About the application

Application number: 2023/91280	
What is the application for?:	Quarrying operations for the extraction of clay, shale and incidental coal and s
Address of the site or building:	Bromley Farm Quarry, Barnsley Road, Upper Cumberworth, Huddersfield, HD8 8PD
Postcode:	S36 4HG

User comments

Type of comment: An objection	
Do you wish your comments to be published on the website anonymously?	Yes

Phase 1 Extraction Single Point Plan

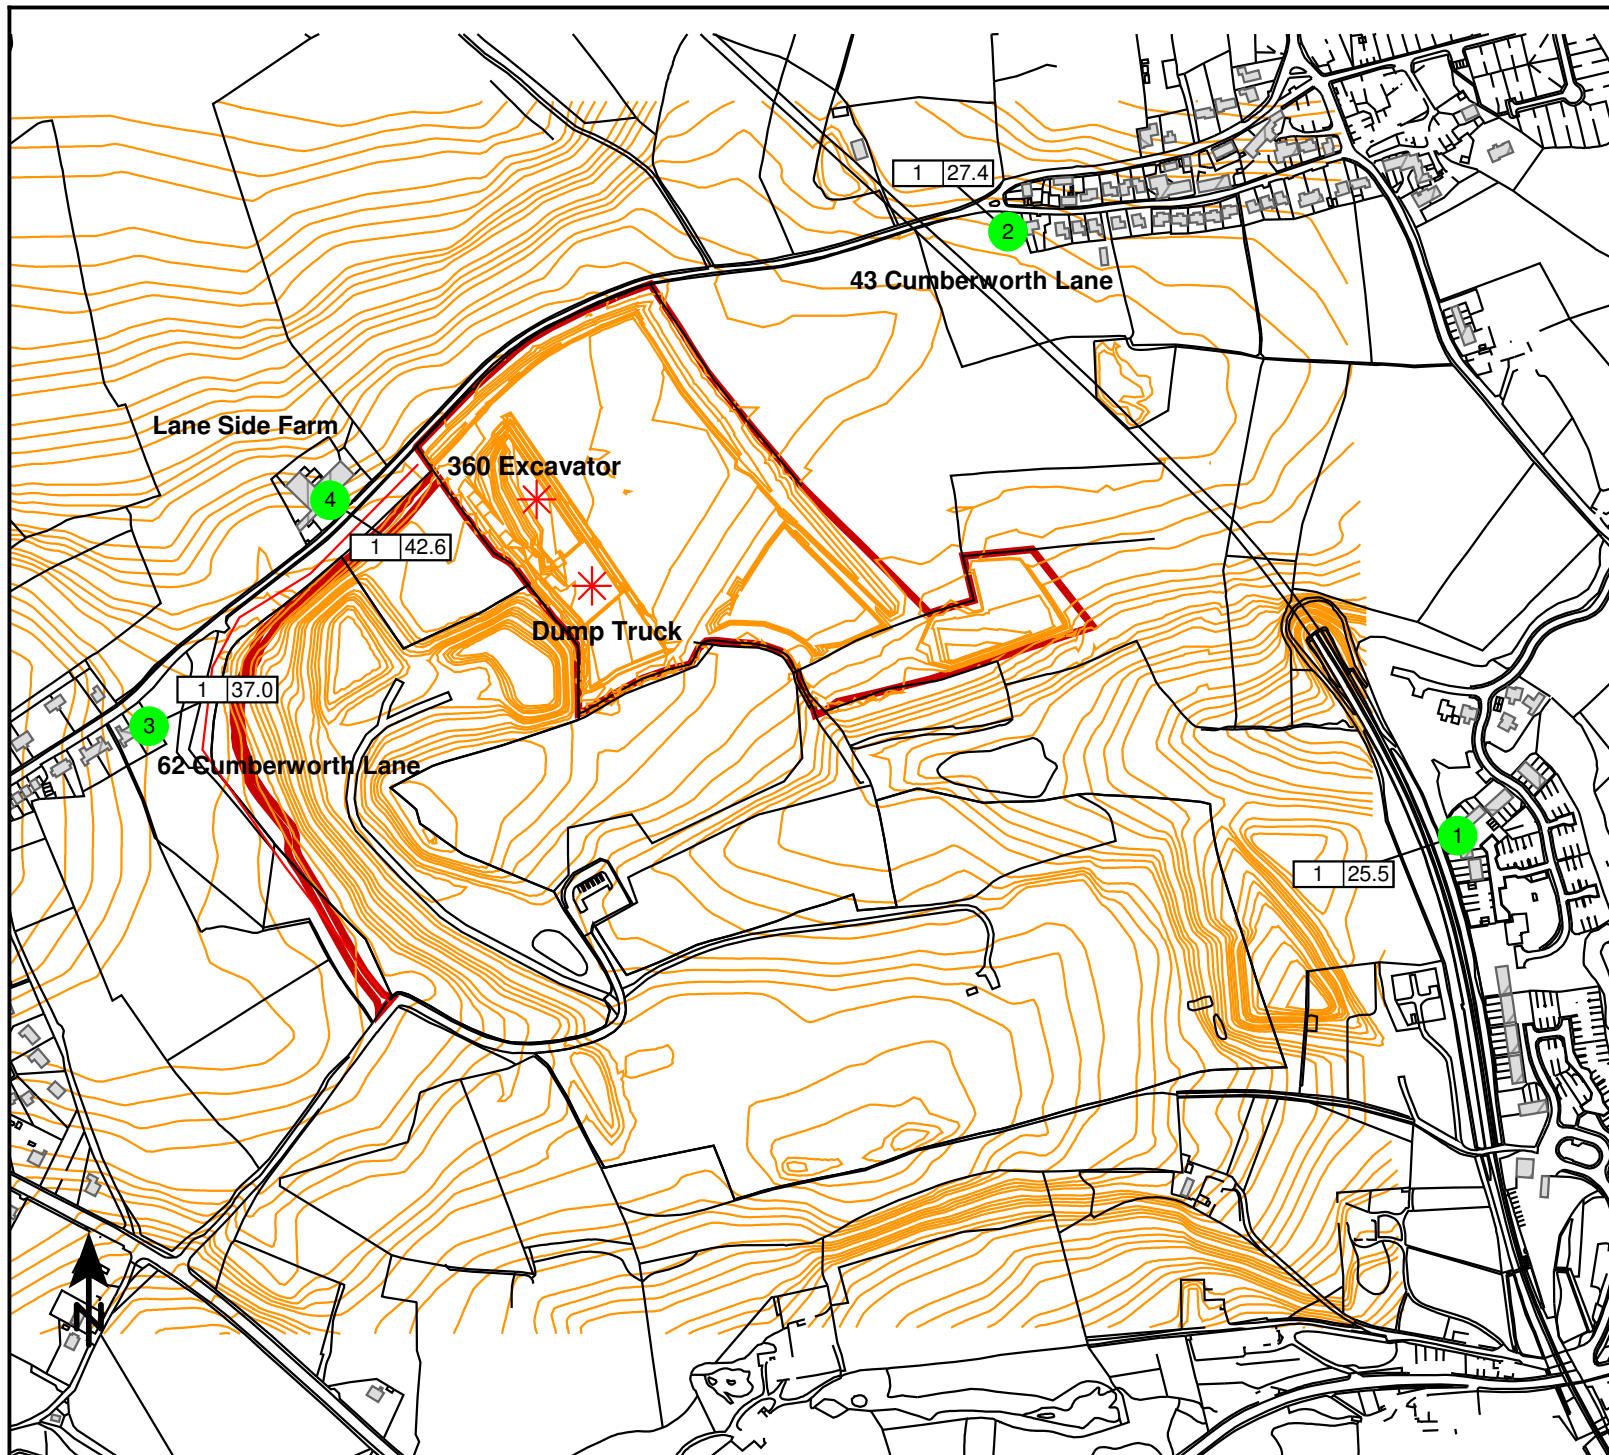
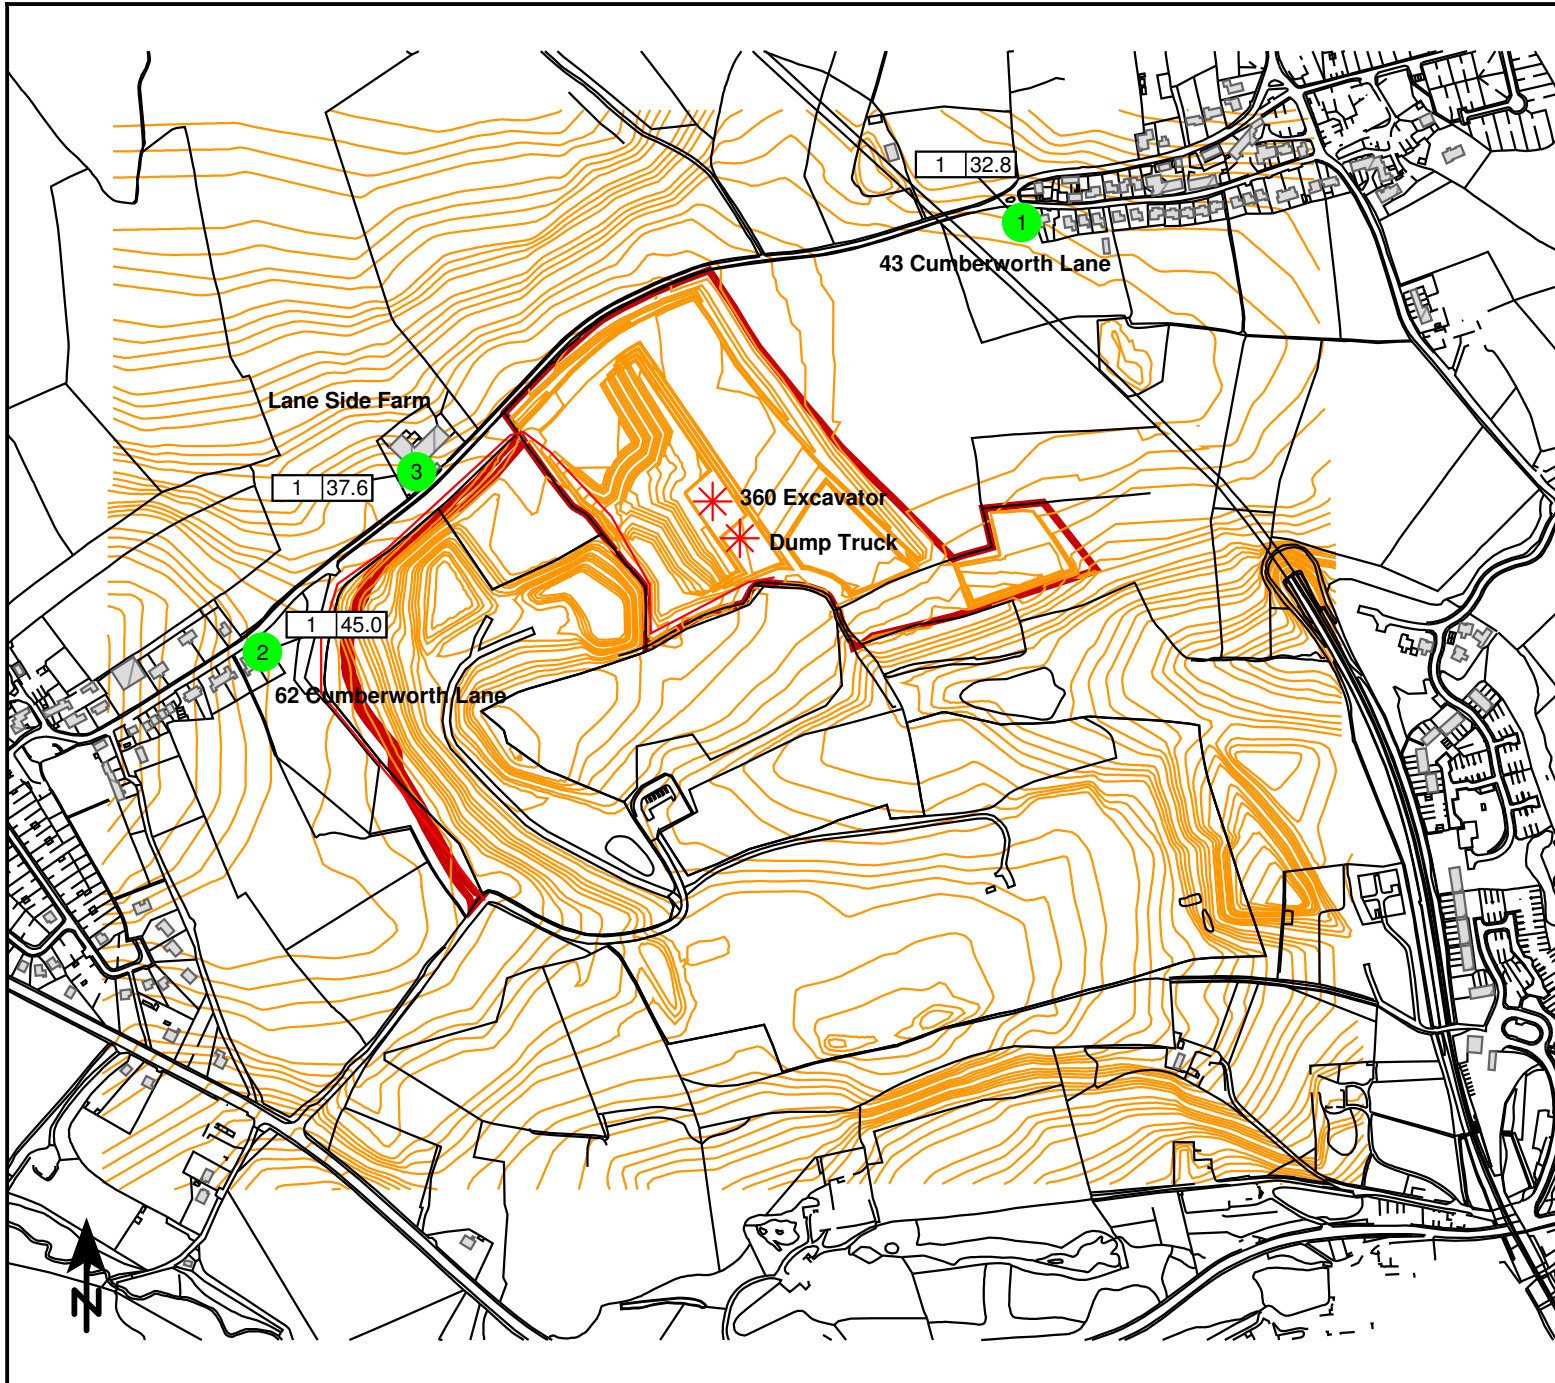
The assessment focusses on the three closest properties, but fails to draw attention to the other affected properties as shown in the drawings at the back of the report. This needs to be highlighted to the residents of Upper Cumberworth in a fair way, not buried in a report appendix.

NPPF technical guidance criteria of no more than 10dB change above background noise where possible, is exceeded in every modelled scenario (even with the poor baseline dataset), not just at the three closest properties but also across large residential areas of Upper Cumberworth. The application fails to draw attention to this, and in every case leans on the criteria for a maximum of 55dB being passable in cases where the 10dB change cannot be complied with.

The increase in noise over the working periods and timeframe is significant and detrimental to the mental well-being of the residents of Cumberworth. People live here for its rural, peaceful character, and wellbeing. Anyone in the impacted zones shown on the maps will hear the quarry activity constantly.
